Planning Statement

176 Maple Road
Hayes
UB4 9NF

December 2022

SHEET TITLE:
PROPOSED SITE PLAN

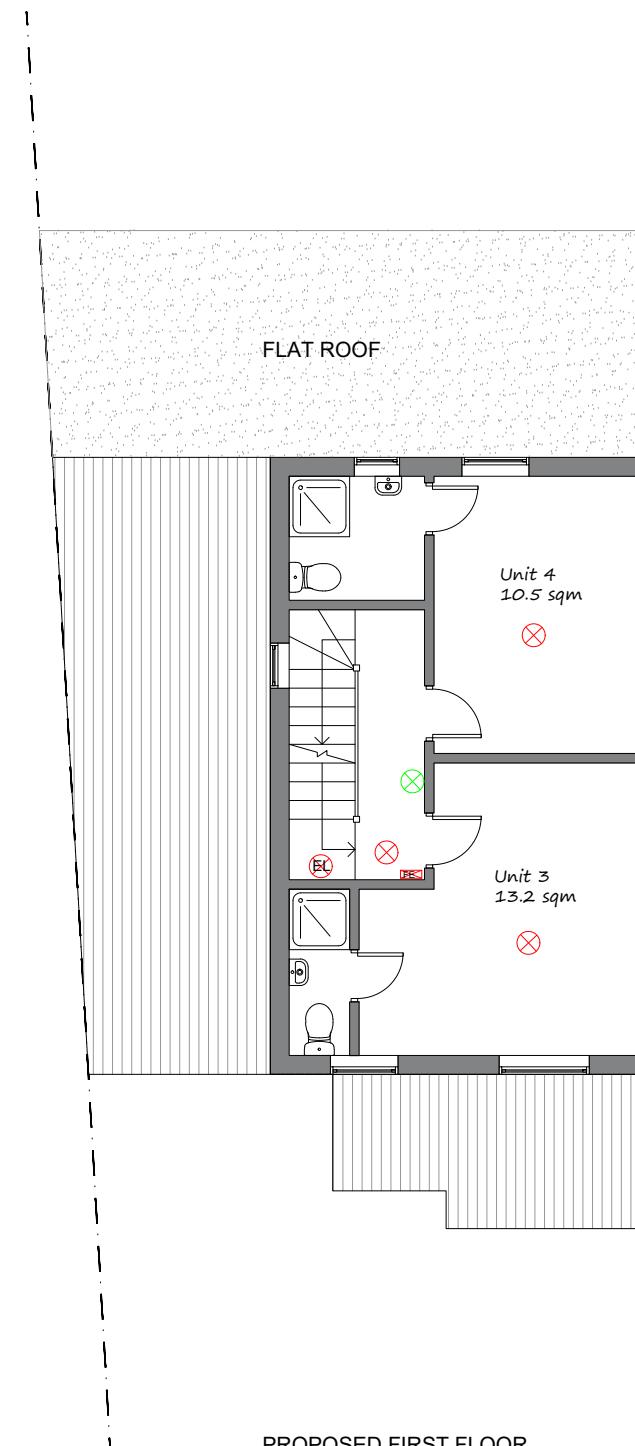
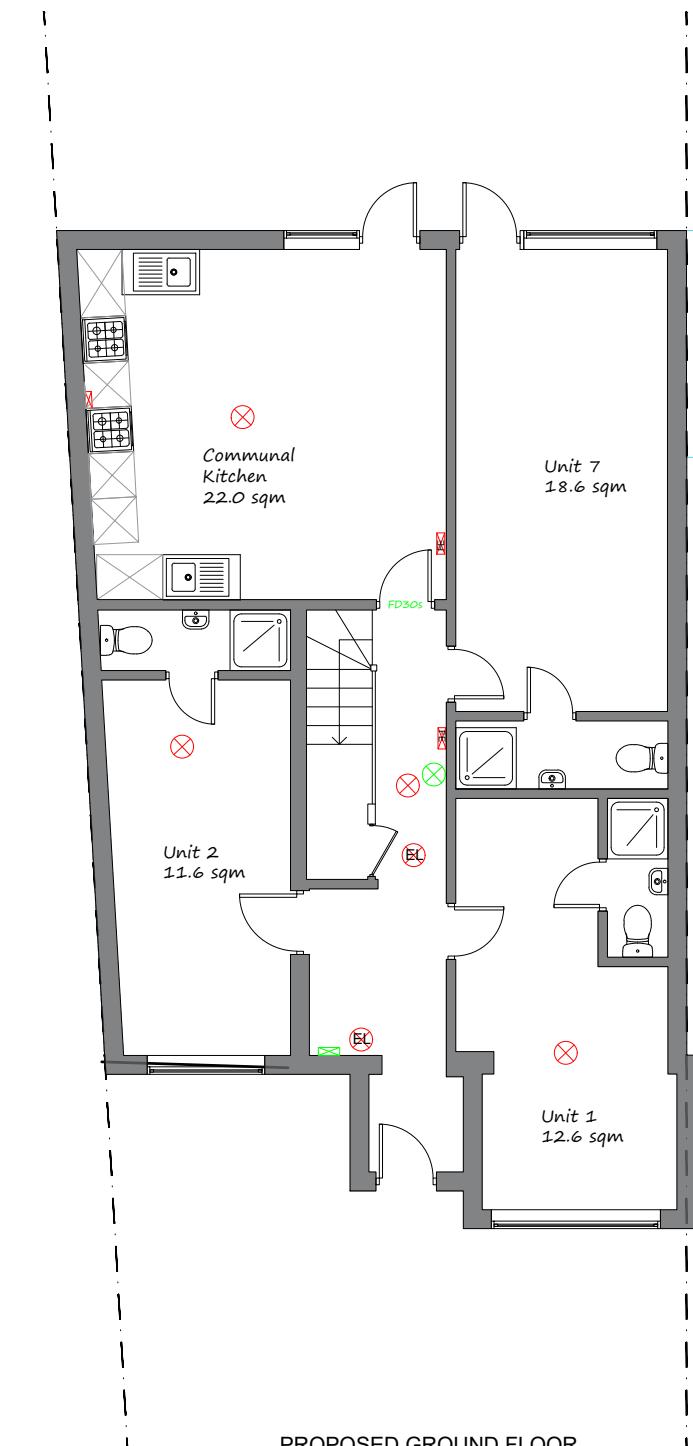
It is noted that objections have been raised by highways officers. The main concerns related to the positioning of the 2 off-street parking spaces (1 of which is an existing parking space) and the lack of an electric vehicle charging point.

Accordingly, a number of changes have been introduced, and a set of revised drawings accompanies this statement. The following has been amended:

- Retention of 1 parking space as per existing dwelling (accessed via existing dropped kerb);
- Cycle storage moved to rear garden.
